Our ref: OUT22/7739

Subject: **McPhillamys Gold Project (SSD-9505) - second Amendment Report**

Detailed advice to DPE Planning & Assessment regarding the McPhillamys Gold Project (SSD-9505) - second Amendment Report

Revised Water Supply Pipeline (Northern Option) Alignment

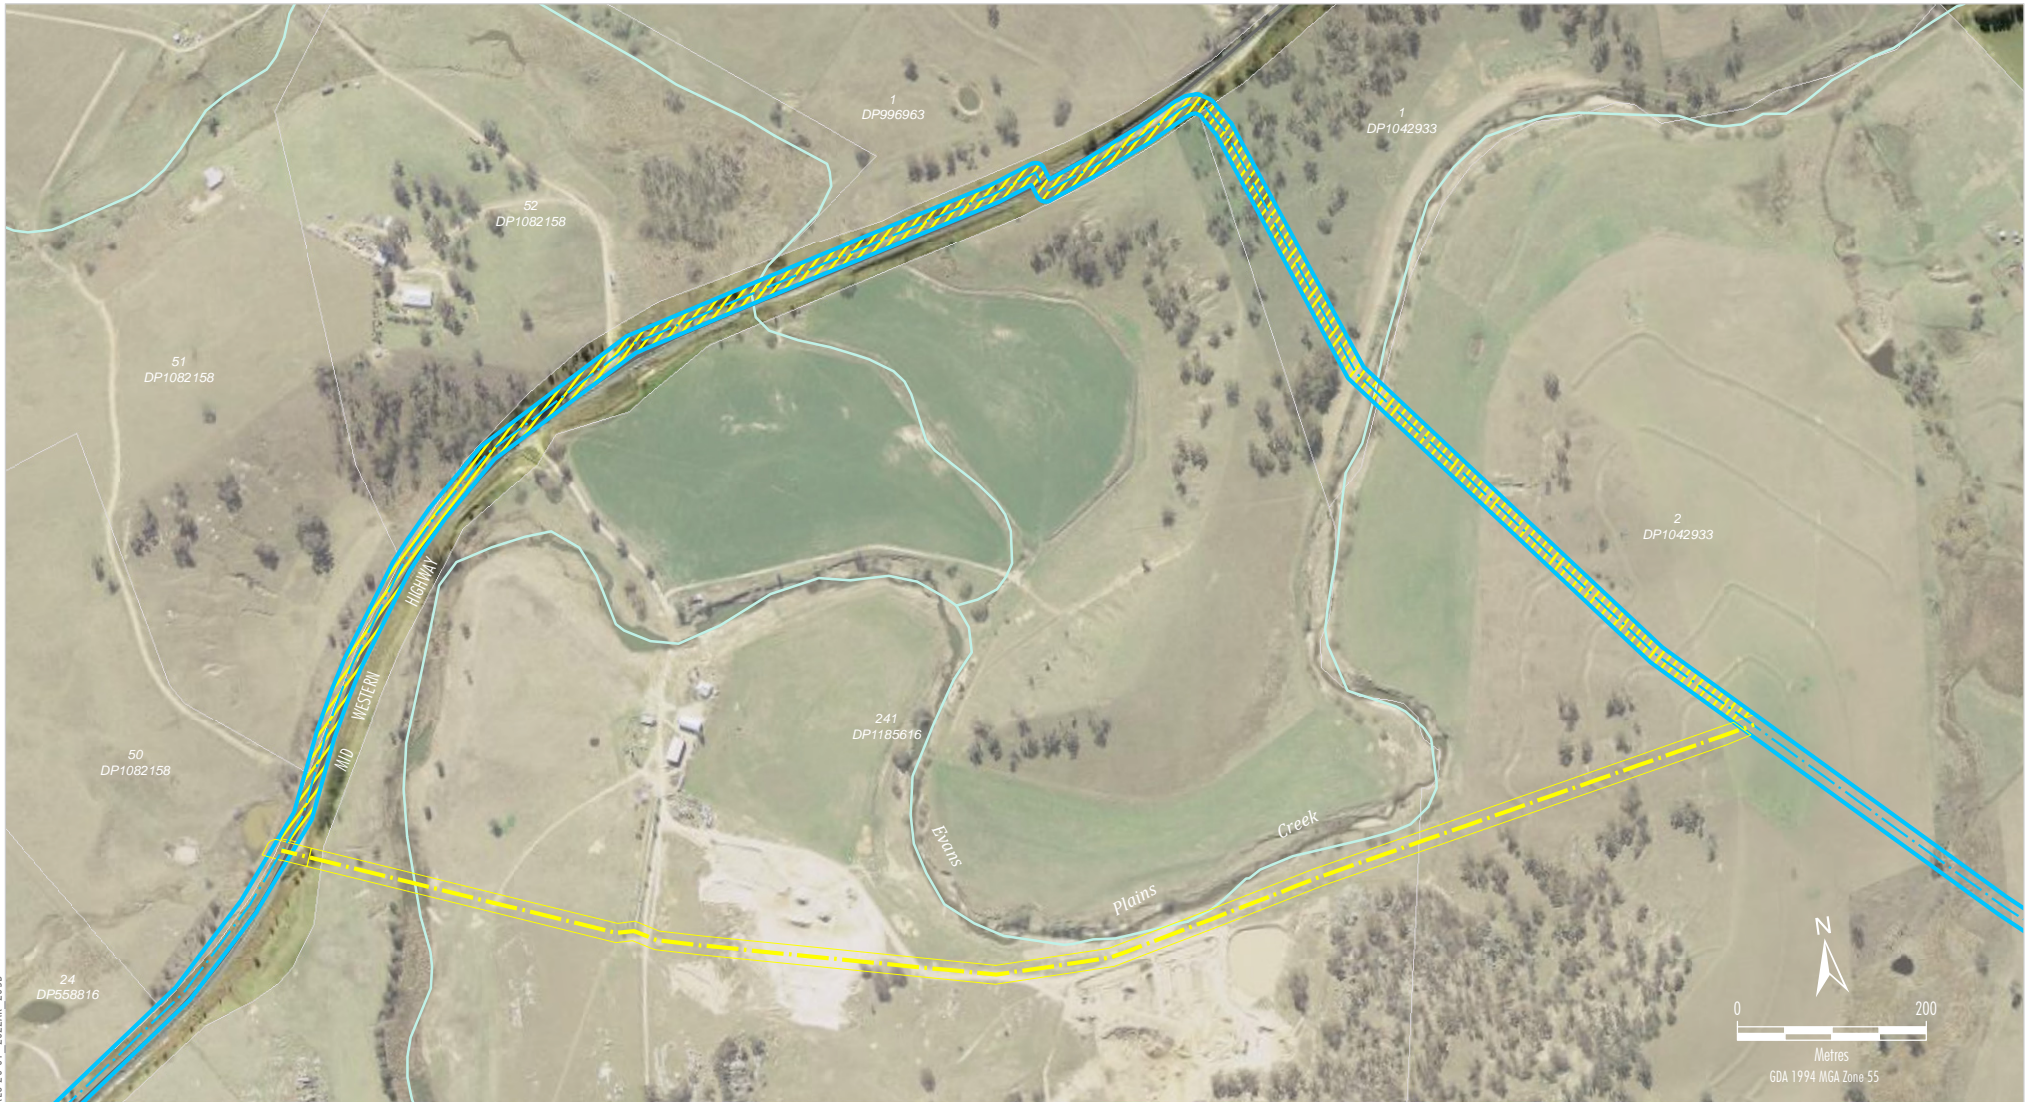
The proposed realignment of the northern pipeline includes an approximate 400m section where it runs parallel to and within close proximity to an unnamed 4th order watercourse. This alignment should be outside of waterfront land to be consistent with the Guidelines for Controlled Activities on Waterfront Land (NRAR 2018).

Open trenching is proposed for the relocated pipeline crossing of Evans Plains Creek. This should be carried out in accordance with the Guidelines for Controlled Activities on Waterfront Land (NRAR 2018).

- the design and construction of the northern pipeline option is in accordance with the Guidelines for Controlled Activities on Waterfront Land (NRAR 2018).
- works within waterfront land are in accordance with the Guidelines for Controlled Activities on Waterfront Land (NRAR 2018).
